From: Robert Findlay
Sent: 26 May 2010 11:17
To: Planning.Responses
Subject: FW: Planning Consultation on: BR/142/10/

APPLICATION **BR/142/10/**
NO:

Registered: 25-MAY-10
Site 207 Chichester Road Bognor Regis PO21 5AQ
Address:

Description of Works: Extension and change of use of an existing office/storage building to a residential use, to provide a total of 3No. 1-bed units. Revised application following BR/73/09.

PROPOSED GROUND FLOOR PLAN

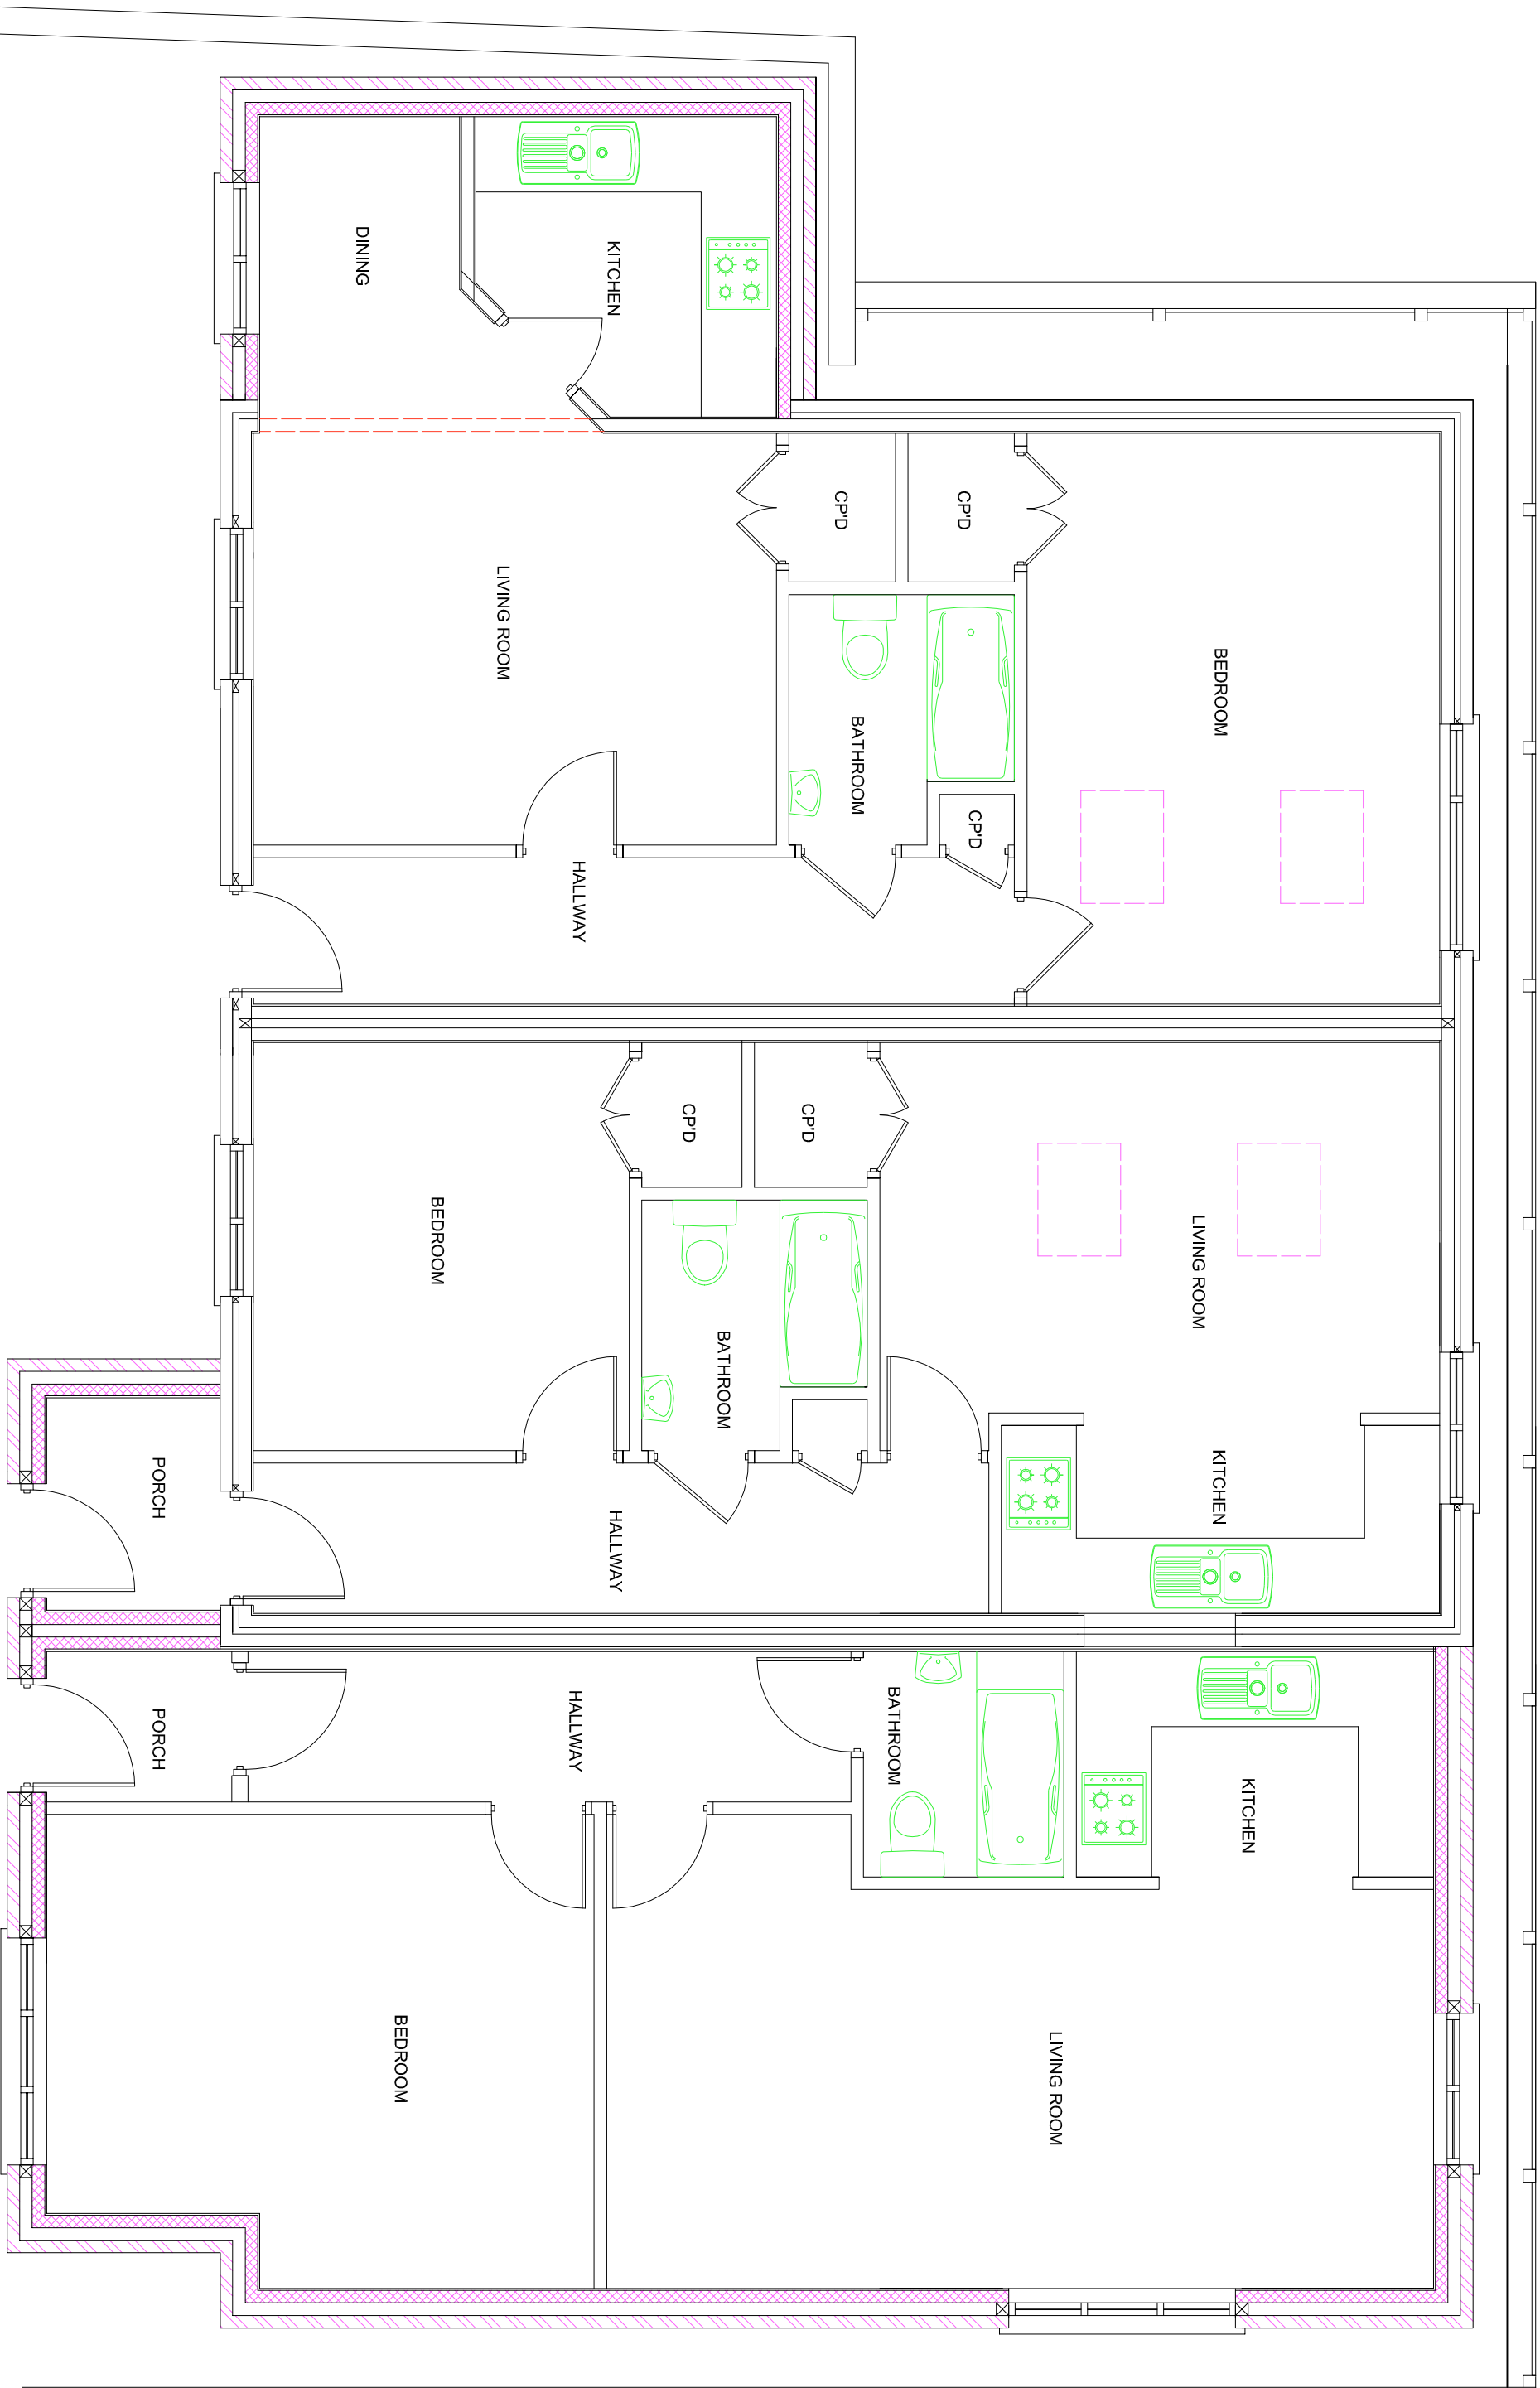
[left hand unit](#)

The kitchen is too small. Discussed issue with architect and agreed that there was enough room in the living room/dining room/kitchen area to increase the available floor area to give at least 5.5 sqm
